MEMORANDUM

TO: Jean Fraser, Planner
FROM: Lauren Swett, PE & Craig Sweet, EIT
DATE: July 6, 2017
RE: One Joy Place, Level III Site Plan Application

Documents Reviewed by Woodard & Curran

- Level III Site Plan Application and attachments, dated April 26, 2017, prepared by Terradyn Consultants, LLC, on behalf of Onejoy Place, LLC.
- Engineering Plans, Sheets C-1.0, C-1.1, C-2.0, C-2.2, C-2.3, C-3.0, C-4.0, C-5.0, C-6.0, C-6.1, P-1.0, dated April 25, 2017, prepared by Terradyn Consultants, LLC, on behalf of Onejoy Place, LLC.
- Architectural Plans, Sheets A1.00, A1.01, A1.02, A1.03, & A2.01, dated May 19, 2017, prepared by Archetype Architects, on behalf of Onejoy Place, LLC.
- Landscaping Plan, L.1, dated April 25, 2017, prepared by Anthony Muench Landscape Architect, on behalf of Onejoy Place, LLC.

BRICK SIDEWALK SECTION

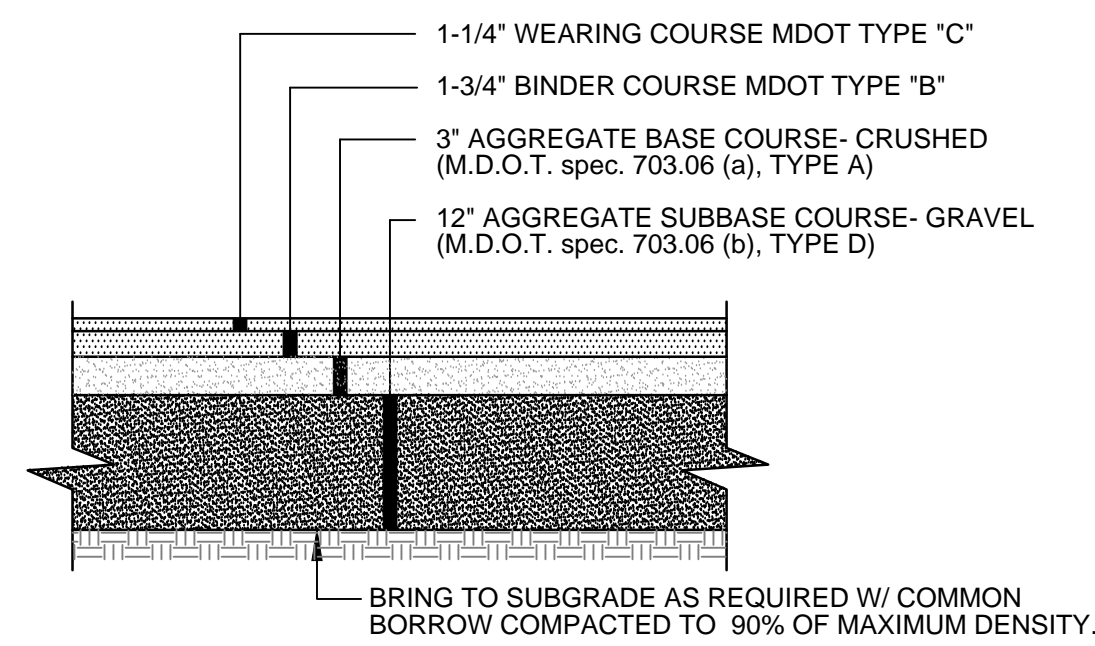
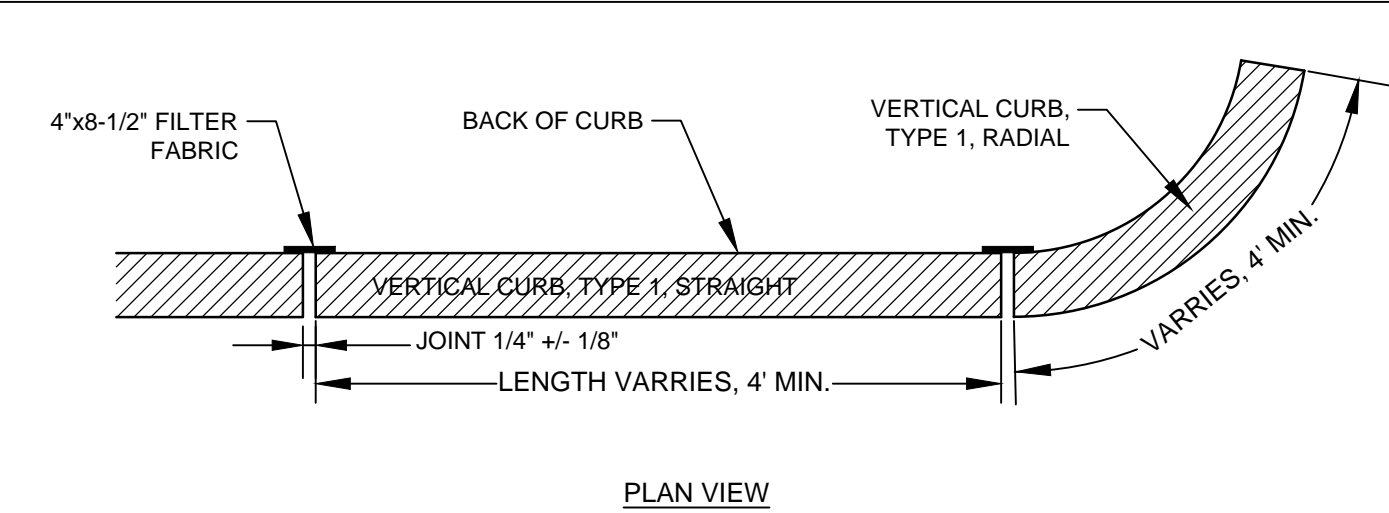
- 4) All work within the City Right-of-Way is required to comply with City of Portland Technical Standards. Brick sidewalk and pavement details for work within the right of way should be in compliance with the Technical Standards.

TYPICAL TRENCH DETAIL
NOT TO SCALE

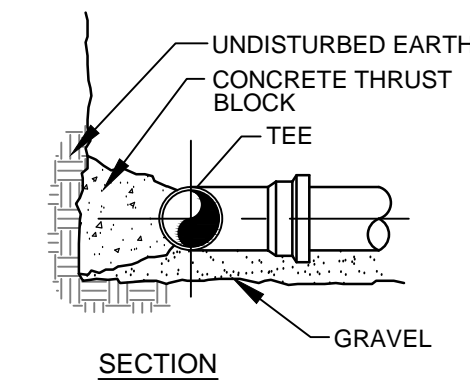
- 5) The pipe burial detail notes that minimum cover is 1 foot. It was noted that in some areas, cover over pipe will be less than 3'. Insulation should be provided in areas with minimal cover to prevent freezing.
